Addendum No. 2

RE: Contract # C204020

Hyde, Dare Counties (F-5702C)

Construction Of One Passenger Ferry

TITLE
MIDSHIP SECTION

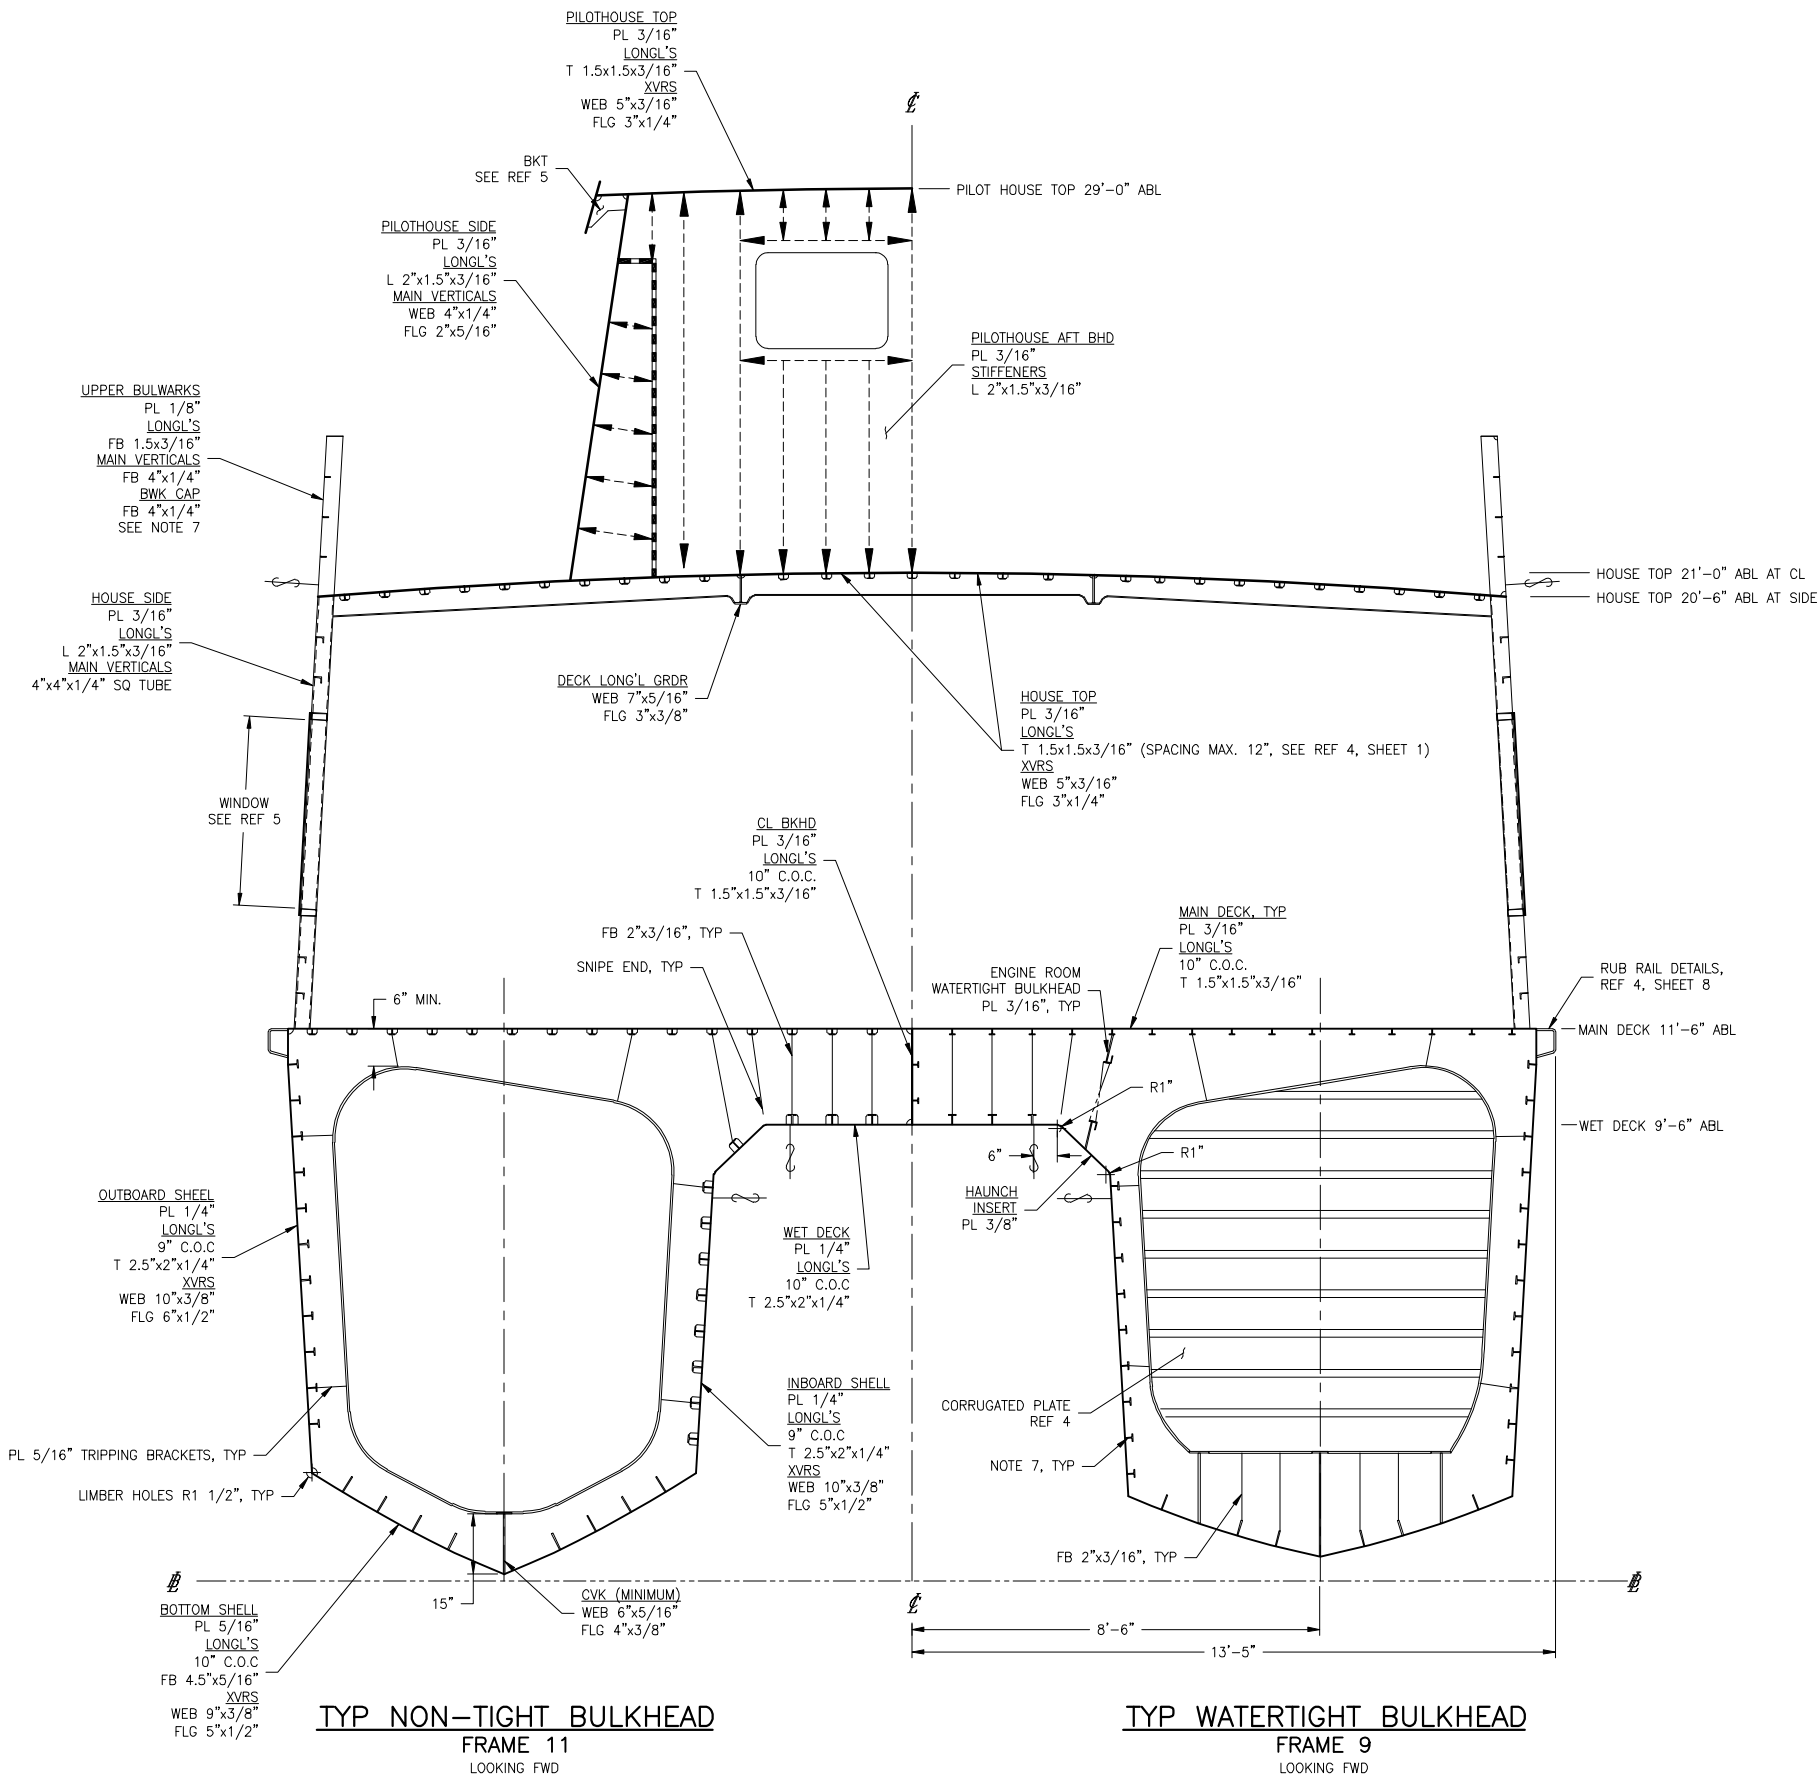
Sheet No.	Revisions
16109-003-110-0, 16109-003-120-0 and 16109-003- 130-0	Revised to add weld symbols. The weld symbols are being added to illustrate the welding standards as stated in the Construction Specifications and Technical Specifications
16109-003-320-0	Revised to reflect generators from parallel arrangement to non-parallel

DIAGRAM 2-3B
 POTABLE WATER SYSTEM VESSEL LAYOUT
 NOT TO SCALE

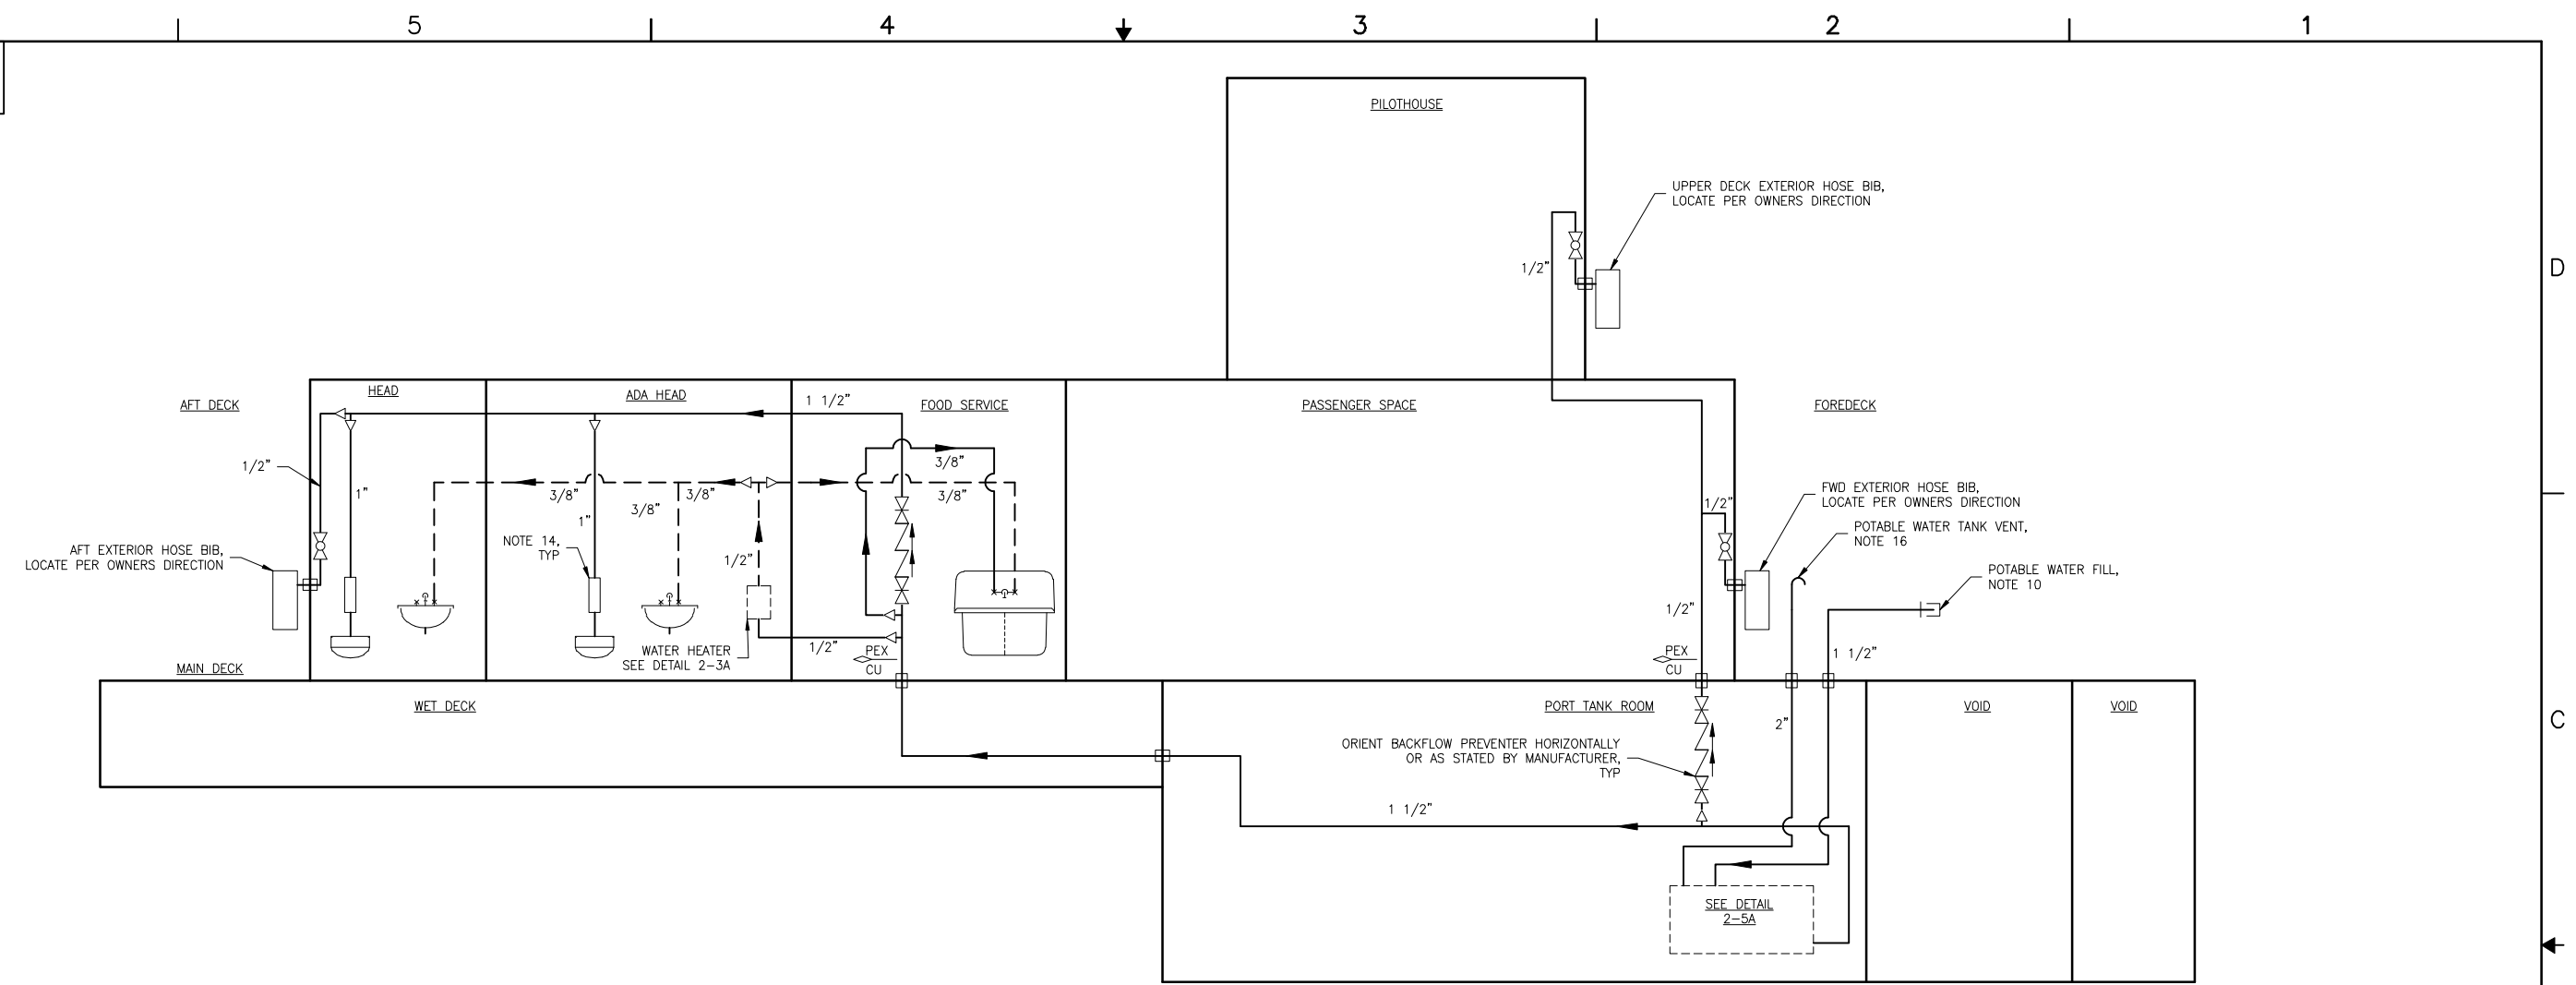
16109-003-533-0	Revised to reflect flex hose connections to the potable water pump
-----------------	--
